East Anglia TWO Offshore Wind Farm

Appendix E1b to the Natural England Deadline 1 Submission

**Comments to the Applicant Comments on Natural England's Relevant and Written
Representations [AS-036] Seascape and Landscape Visual Impact Assessment
(SLVIA)**

2nd November 2020

**Figure: 28.35c**  
**Viewpoint 11: Suffolk Coastal Path, between**  
**Thorpeness and Sizewell**

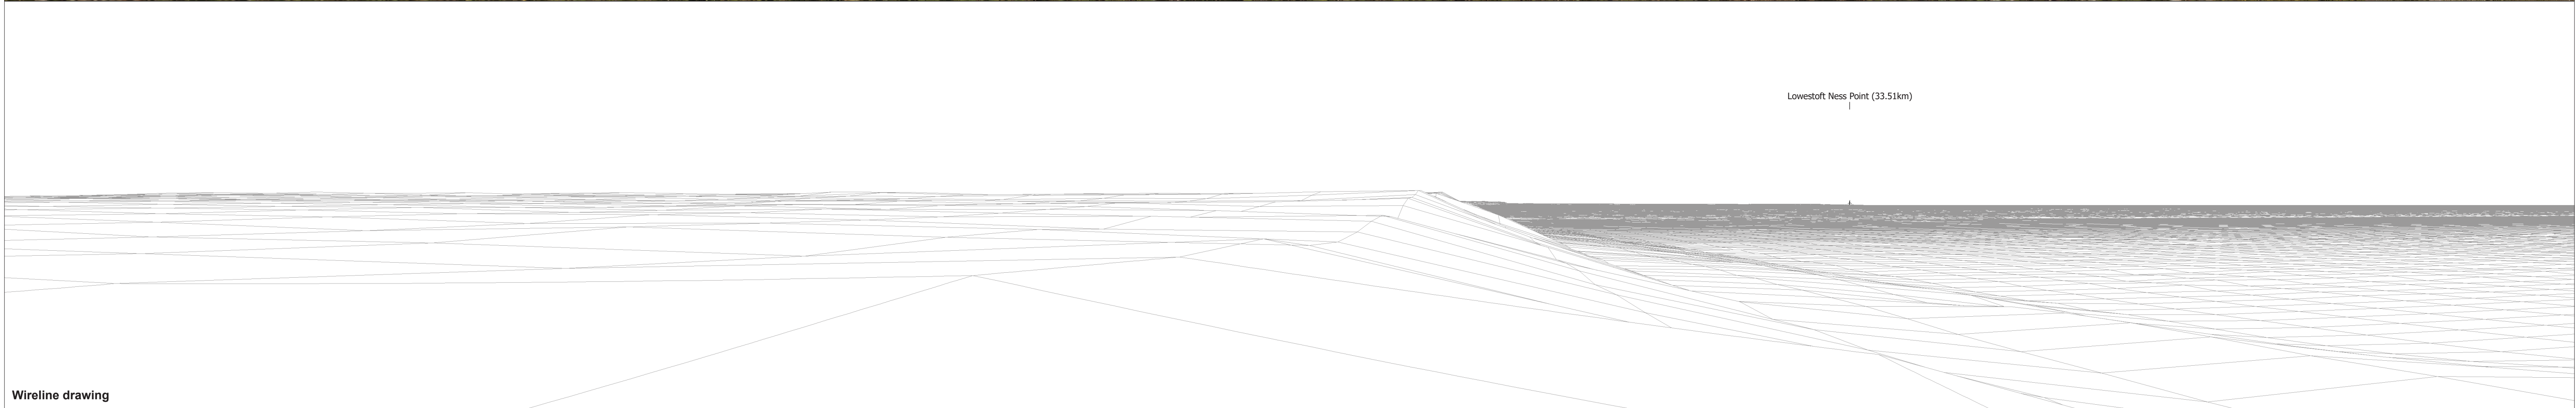
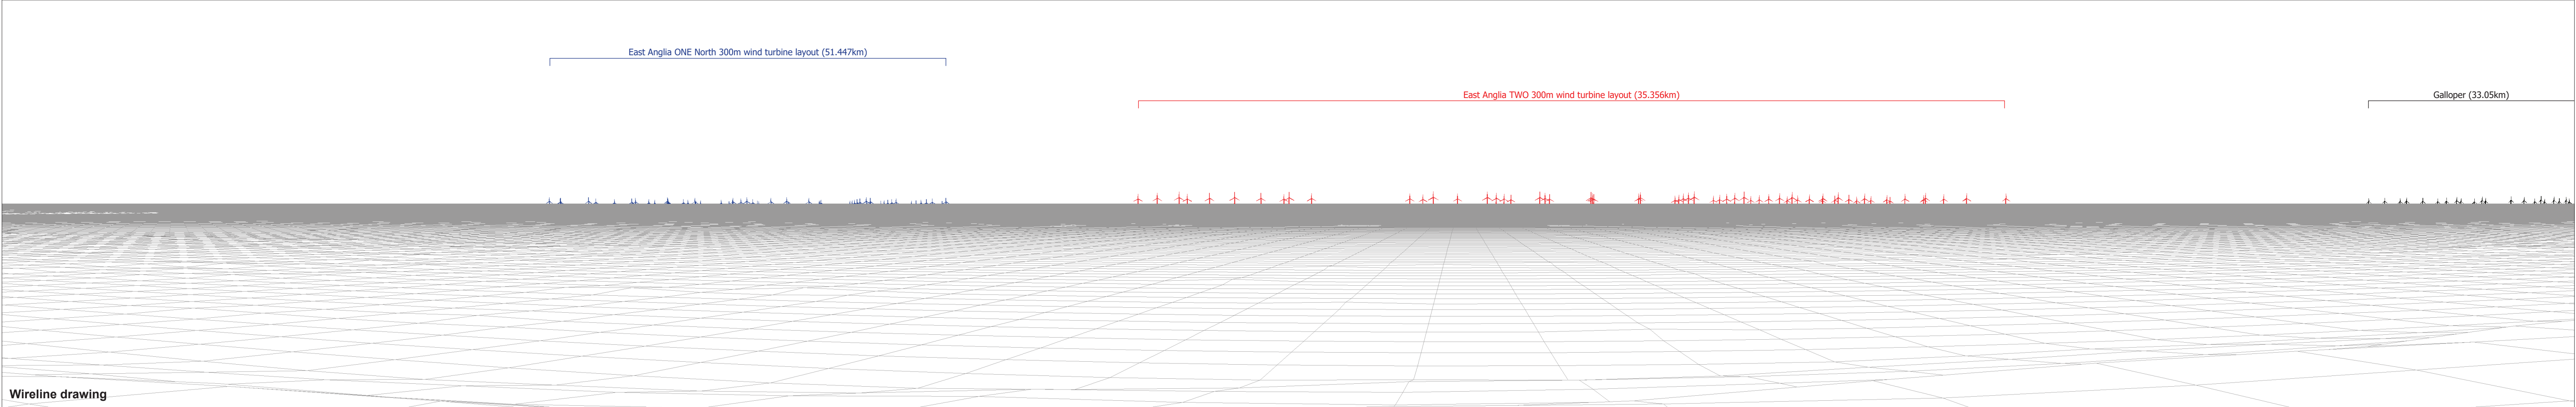
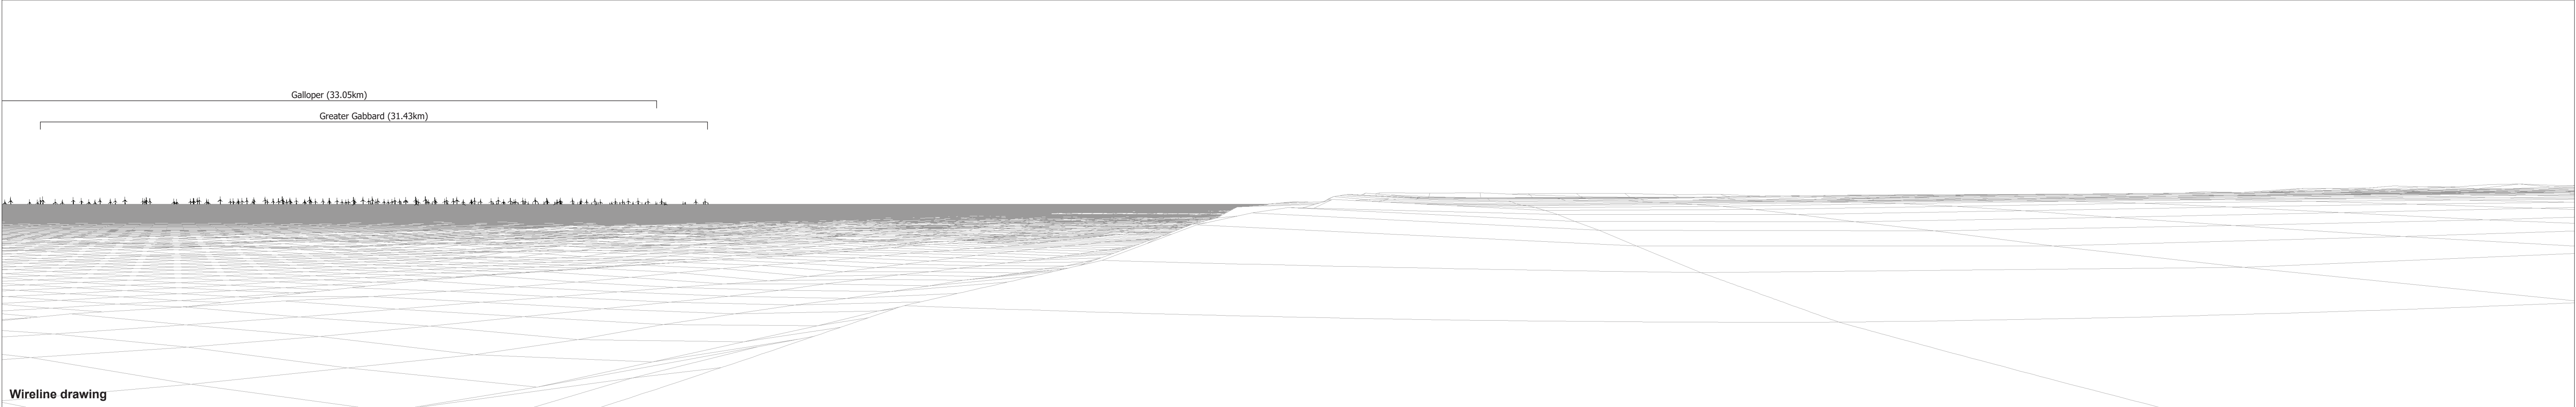
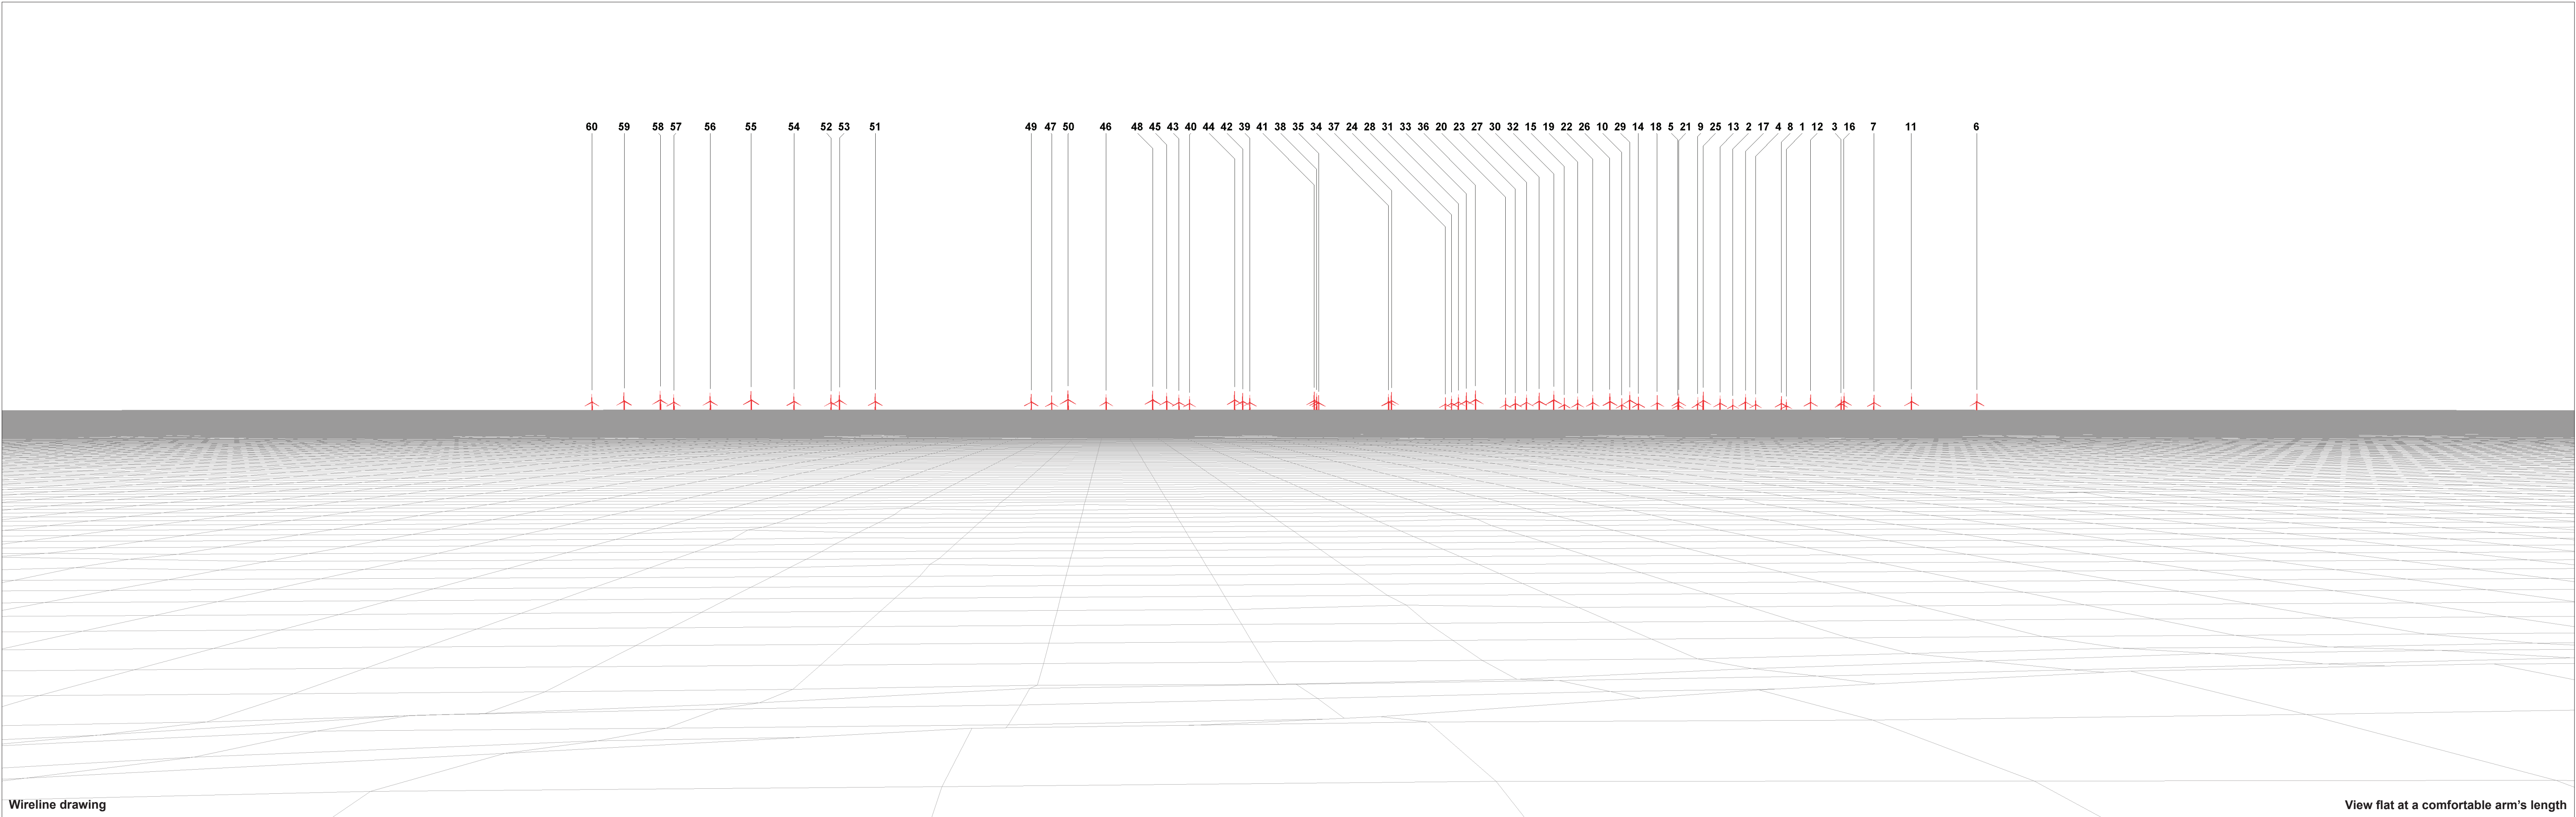
Point	Comments and issues						Risk	EA1N	EA2
	11	Suffolk Coastal Path (between Sizewell and Thorpeness)	11.34	282	34.8	0.412			
	12	Thorpeness	4.68	282	35.1	0.383			
	13	Aldeburgh	5.96	282	35.9	0.376			
	18	Orford Ness	5.8	282	37.4	0.352			
	A	Southwold Common*	13.00	282	32.1	0.464			
	B	Southwold Pier	7.0	282	31.4	0.460			
	<p>As a result of this recalculation the maximum apparent height value has decreased from 0.467 to 0.450.</p> <p>*EA2 is not visible from this viewpoint.</p>								
NE - 3.3.4 Continues (p.423)	Ongoing: NE notes the reduction in the magnitude of change judgements for Covehithe. For the reasons we set out at NE 3.7.2 (p.432) we disagree with this adjustment from medium to medium-low.							N	Y
NE 3.3.5	<u>Ongoing: NE advises that there are still cumulative effects from the presence of EA2 in conjunction with EA1N</u>								
NE – 3.4.1	<p><u>Night-time effects</u></p> <p>NE welcomes the Applicant’s commitment to reduce the intensity of the aviation lighting to 200cd whenever</p>							Y	Y

Figure: 28.33e
Viewpoint 9: Minsmere Nature Reserve

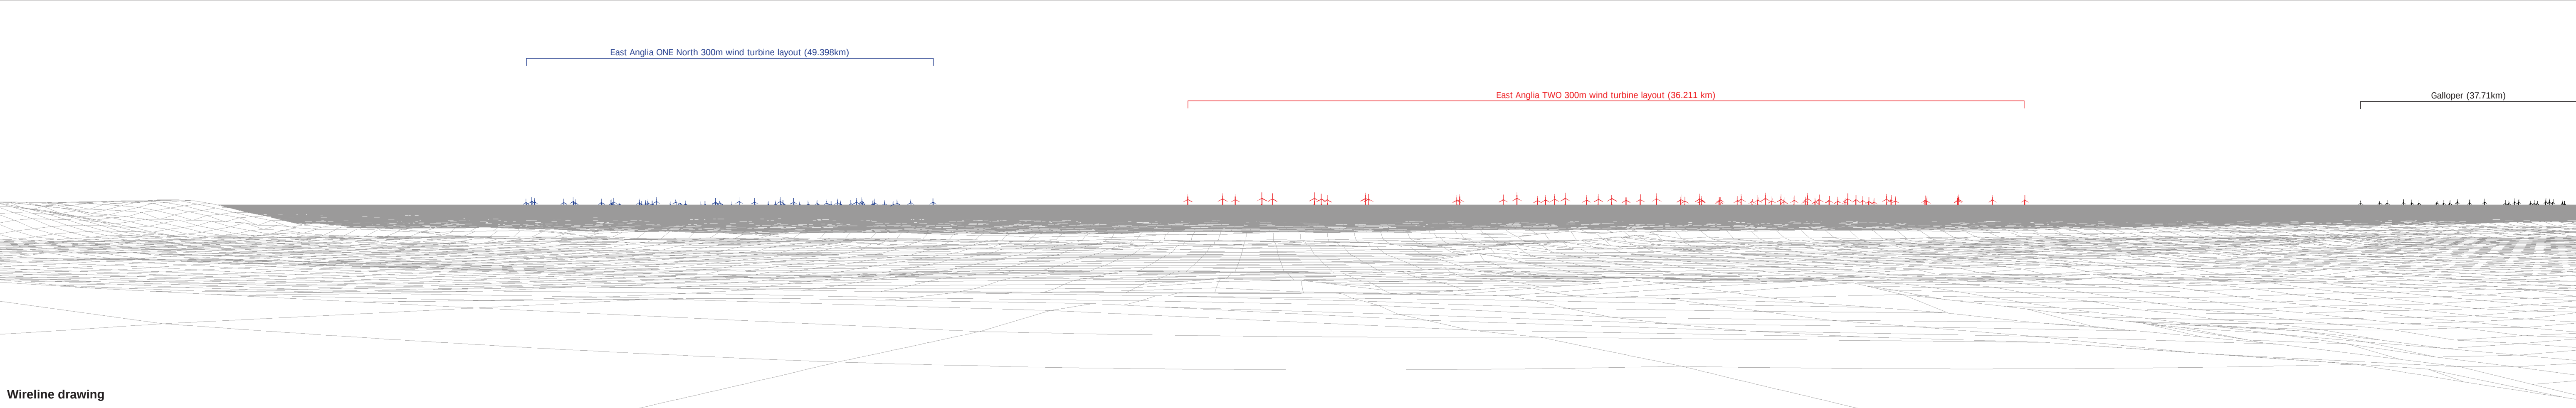
<table><tr> <th>Viewpoint</th> <th>Name</th> <th>Stated eye level height of viewer (m)</th> <th>Turbine Height to blade tip (m)</th> <th>Distance from the Project (km)</th> <th>Apparent Height (degrees)</th> </tr><tr> <td>9</td> <td>Minsmere Nature Reserve</td> <td>15.55</td> <td>282</td> <td>35.2</td> <td>0.416</td> </tr></table>
